2 Fig Tree Drive (Site 53), Sydney Olympic Park

Design Excellence Competition - Jury Report

February 2015

BUILDING HEIGHTS - COMPLIANT

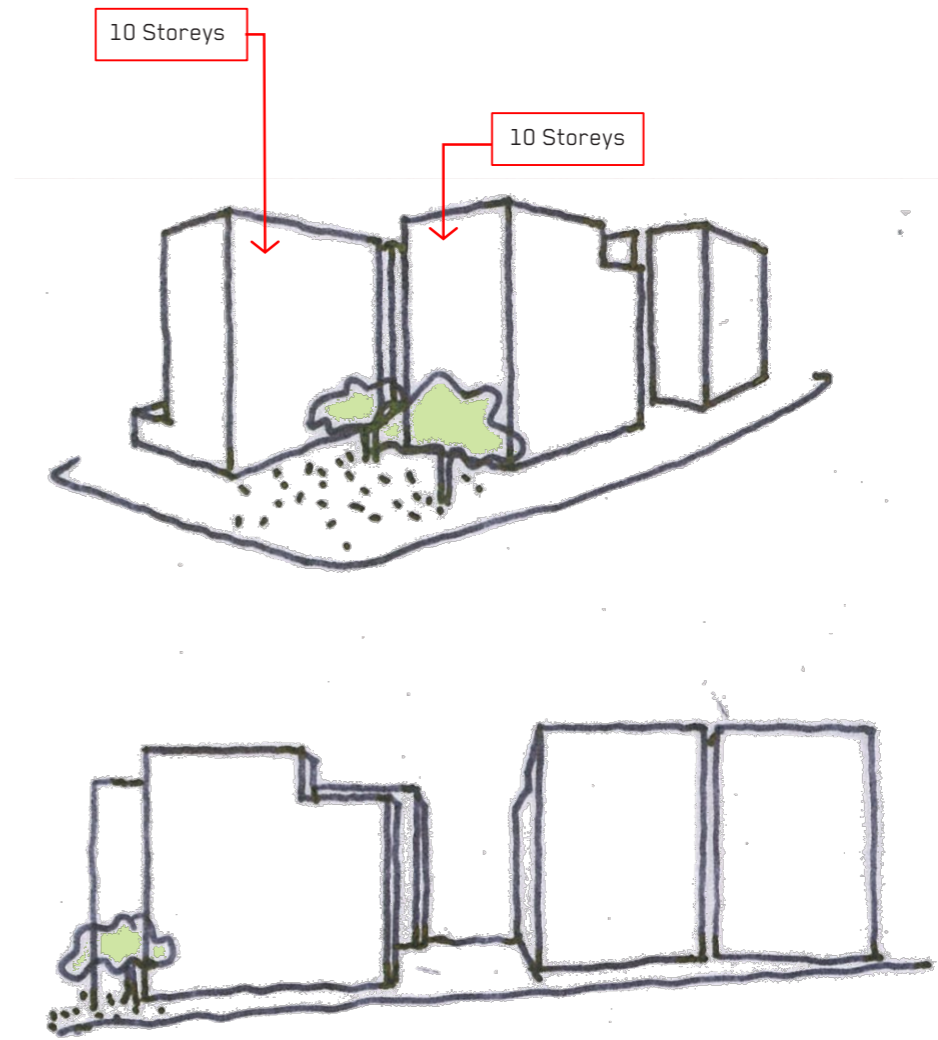
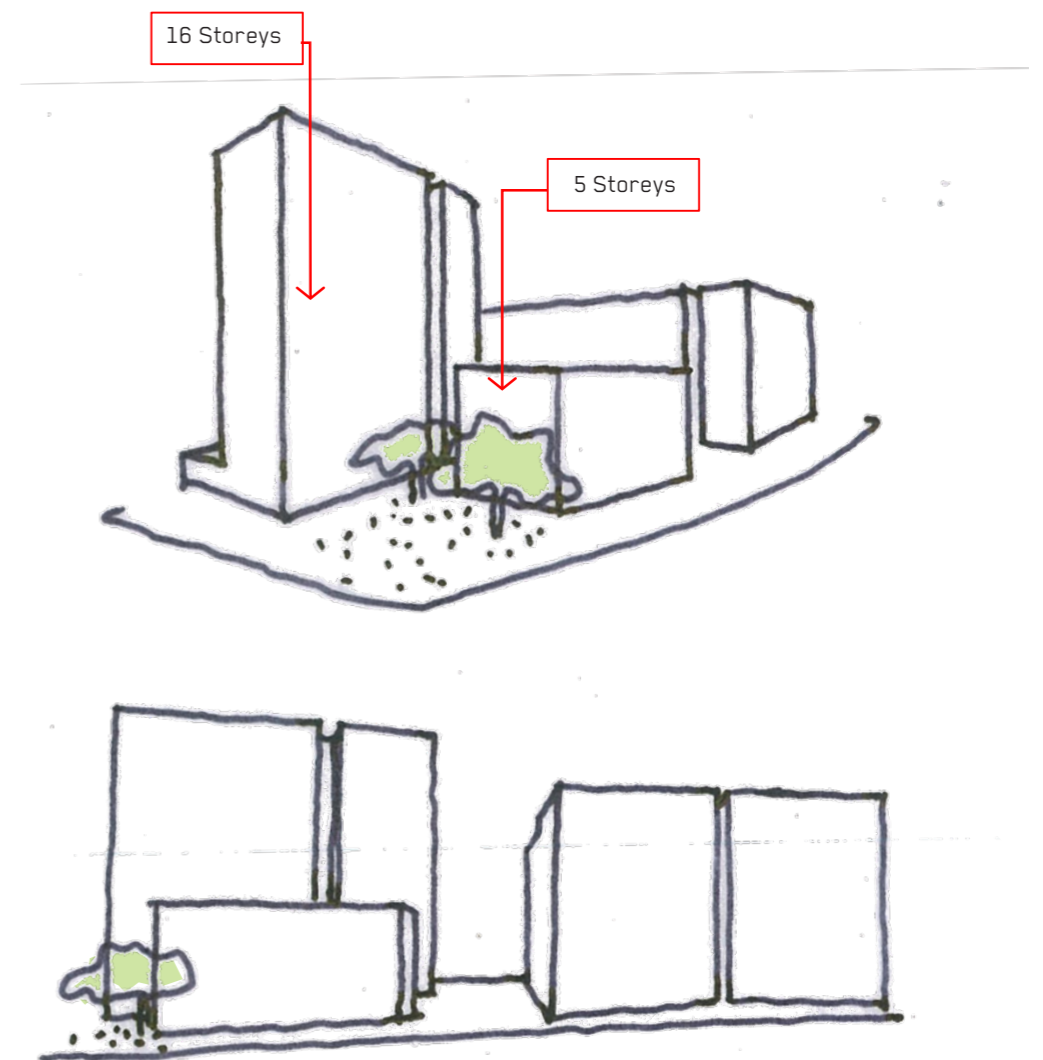
The '*alternate scheme*' proposes to increase the height of the southern building to 16-storeys creating a more successful transition between the 30-storey residential towers on Australia Avenue to the future desired lower scale character of the Central Precinct to the west. While the Jury supports the intention and urban design merit of the additional height at the south-east corner of the site, concern was raised regarding the significant non-compliance with the statutory controls.

The Jury is of the opinion that the variety in height enriches the '*alternative scheme*' and should be explored further in order to achieve the correct balance and transition of scale.

The proposed façade treatment of the buildings to the south and west is not as successful and could be improved. The use of rough cast white render becomes severe on the taller 16-storey structure. Further consideration of the massing, material pallet and exploration of façade articulation could assist.

PODIUM-GROUND FLOOR PLAN 1:500

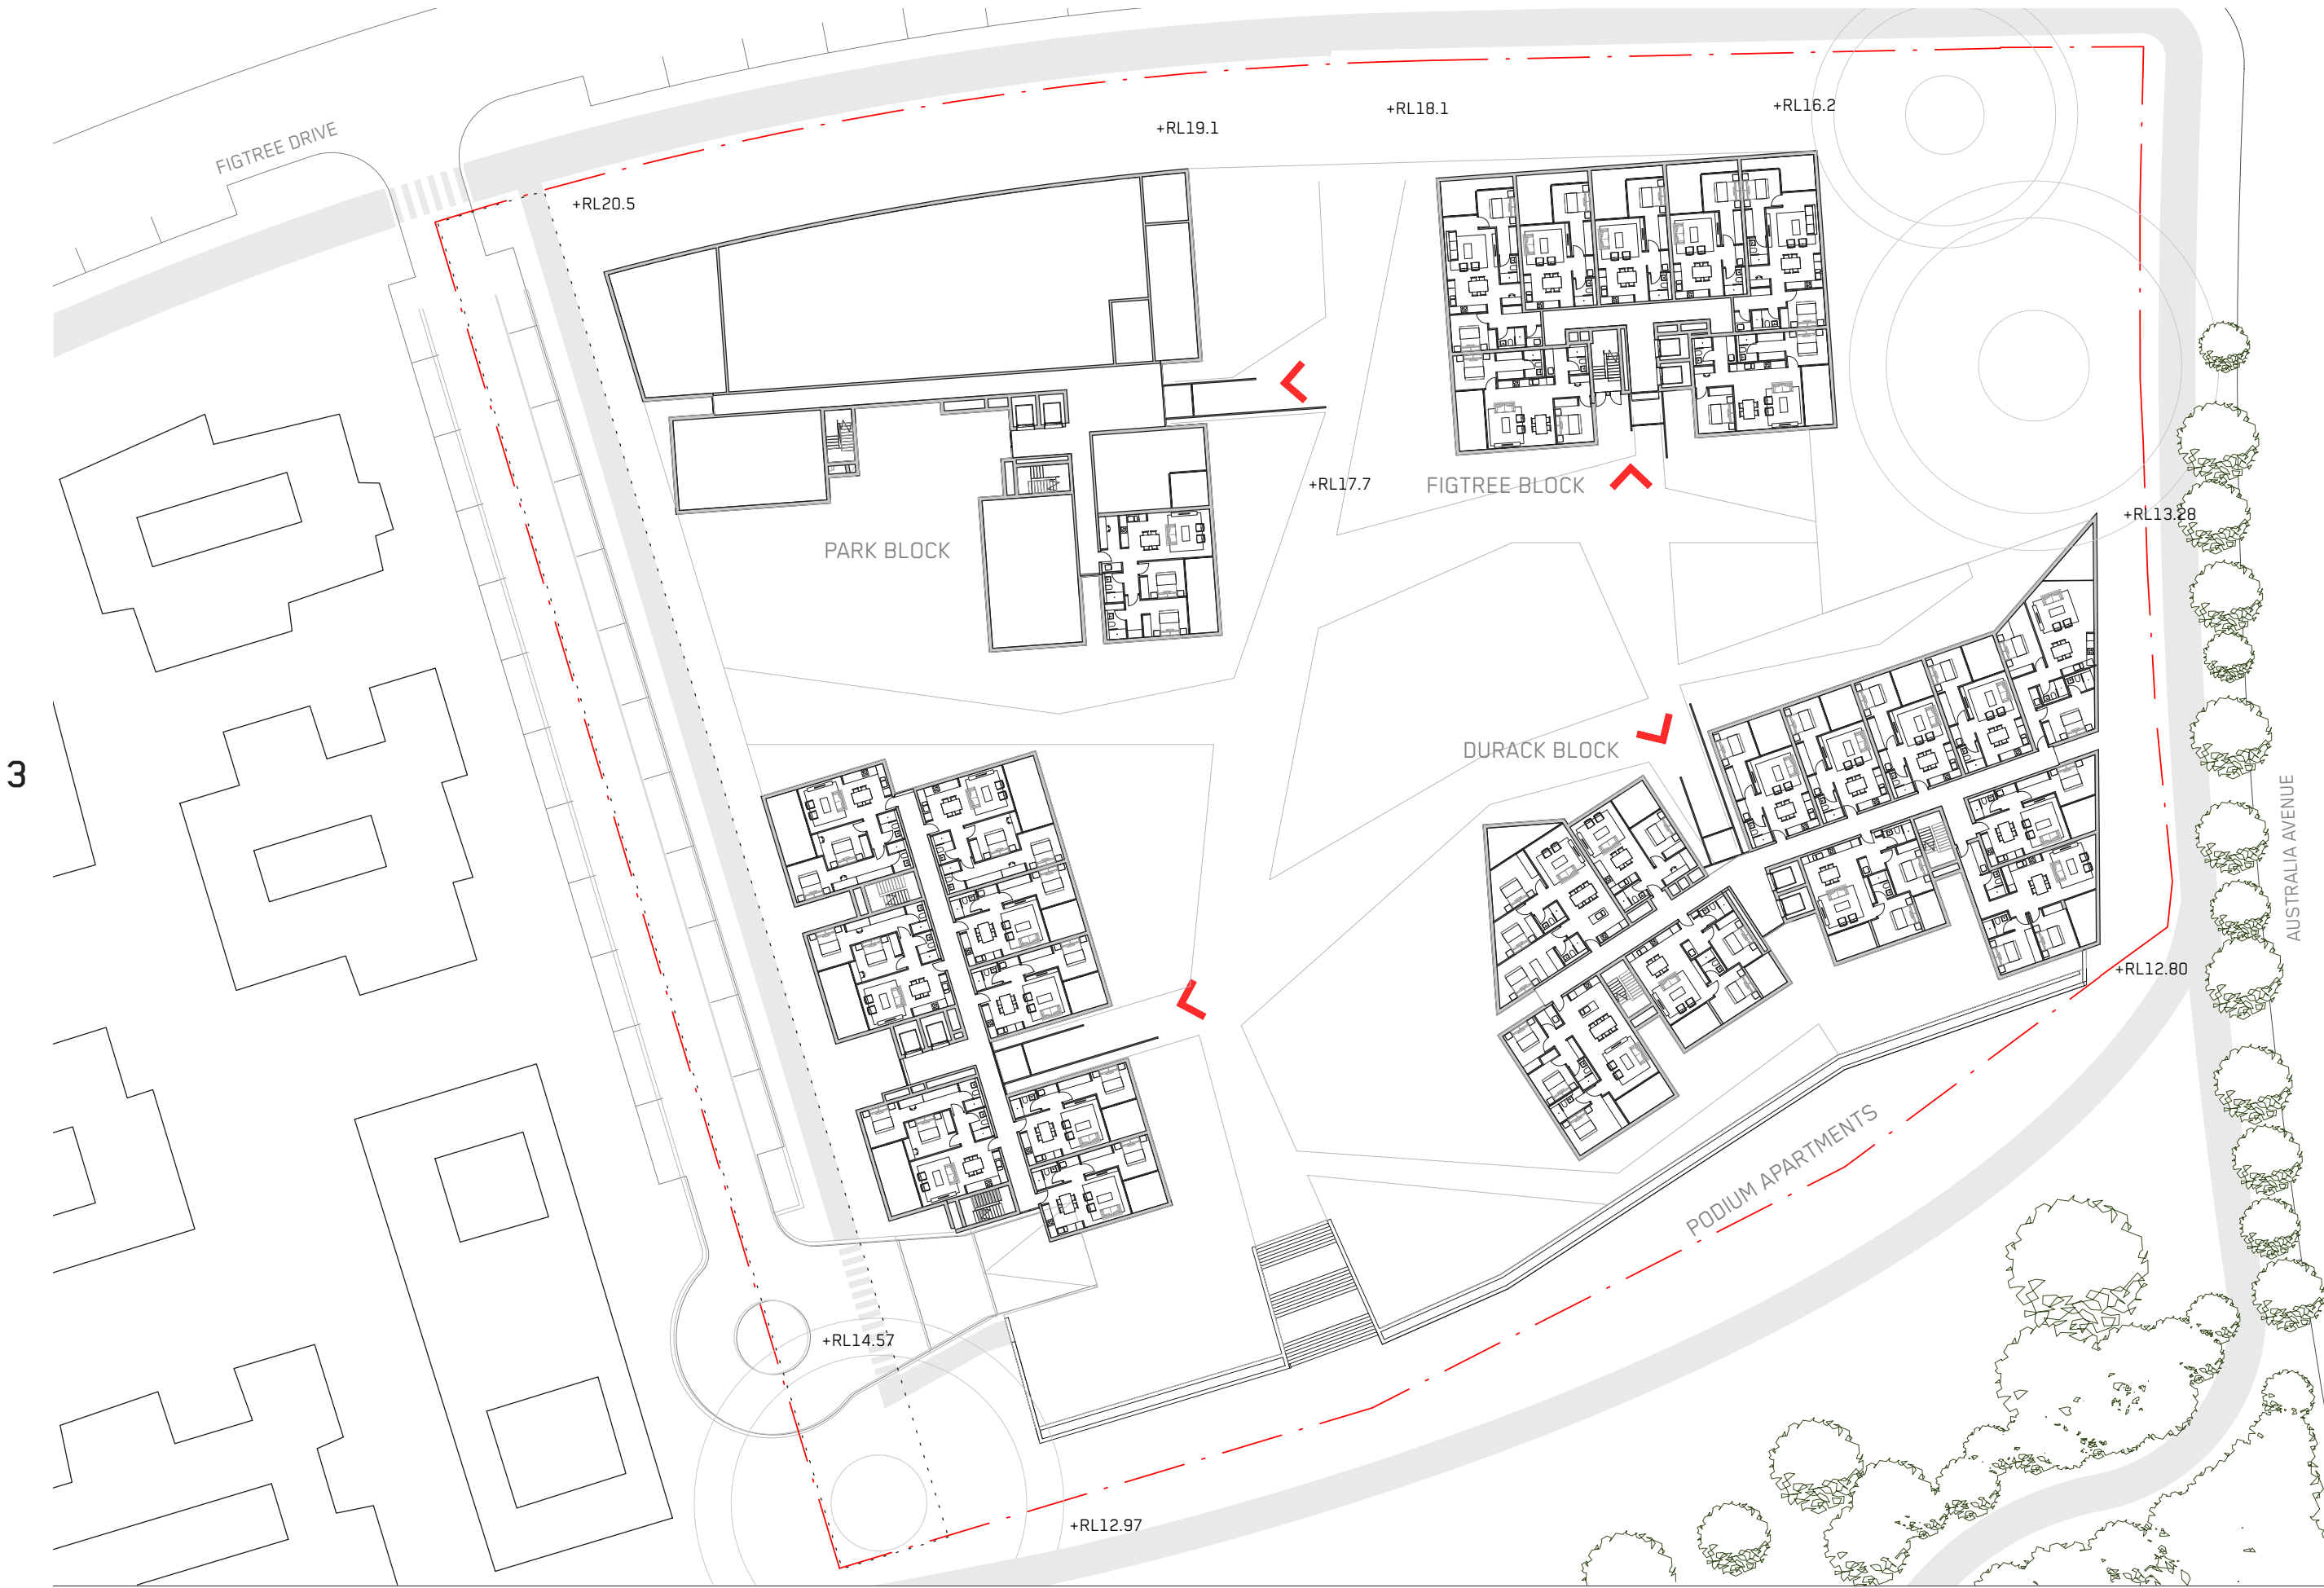
The proposed ground plane incorporates grand entry spaces to apartment lobbies, an active zone through the centre, turf areas, and the potential for a children's playground to the south-west. The usability of the internal courtyard is improved through the reduction in scale of the northern building. However, further consideration of the nature of public and private spaces is required. In addition, solar penetration to the internal courtyard space should be explored.
